REPORT UPDATE

Application No: AL/20/18/OUT

REF NO: AL/20/18/OUT

PROPOSAL: Outline application for the demolition of 2 No. dwellings & associated outbuildings & the erection of up to 27 No. dwellings, of which 30% will be affordable, with associated open space & access. This application is a Departure from the Development Plan.

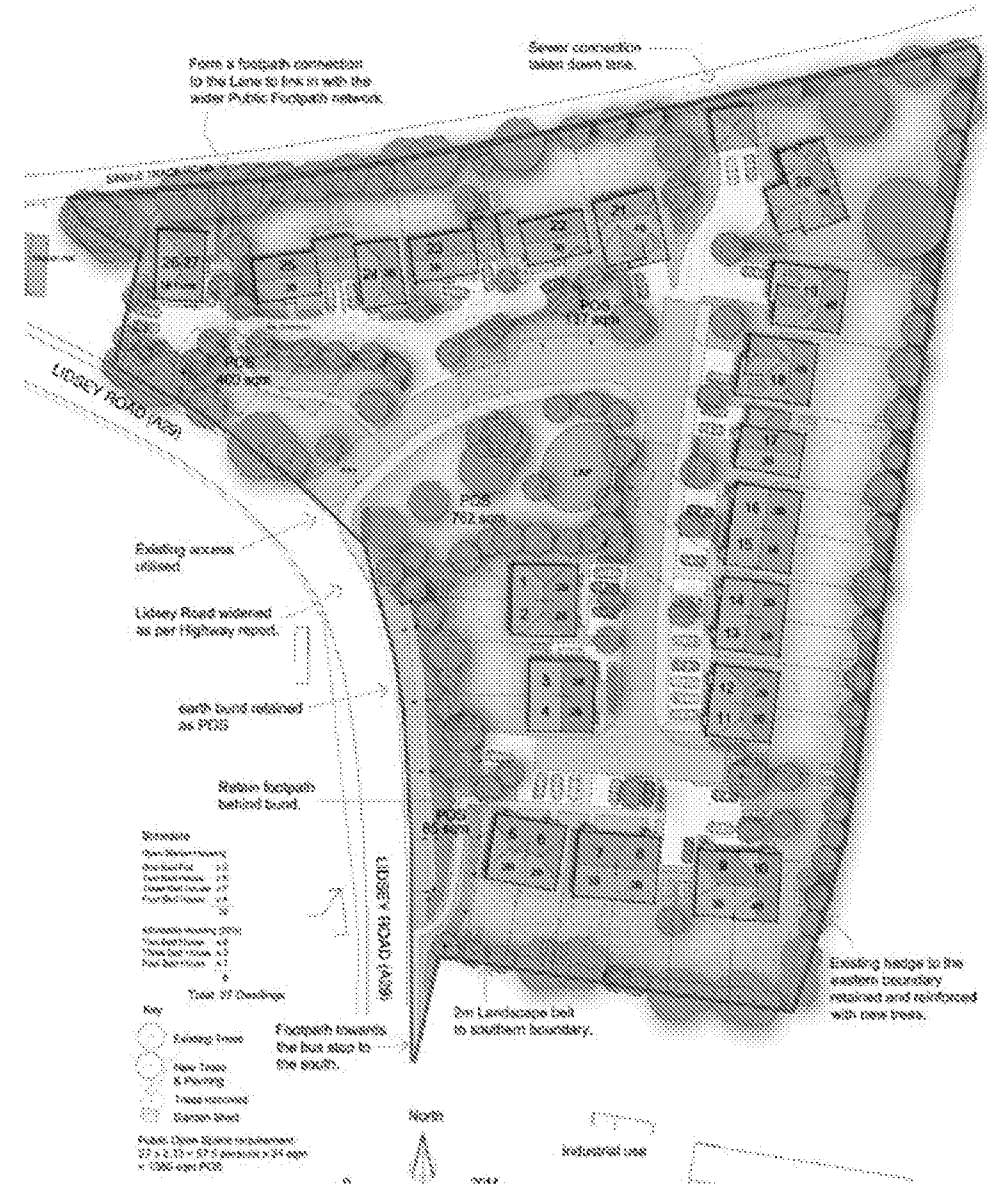
- The amended illustrative site plan (Drawing 1749-02H) shows the lane widths on the bend adjacent to the site access appear to vary in width. With regard to what is shown, approximately 10 metres south of the proposed centreline of the new access, the southbound lane width appears to be 2.5 metres wide. Given that the A29 in this location carries a high proportion of heavy goods vehicles, vehicles might over-sail the centreline when travelling south.

- With regard to bellmouth radii, it is unclear what is proposed because the dimensions, kerb-lines shown do not correspond with one-another and are generally unclear on the drawing.
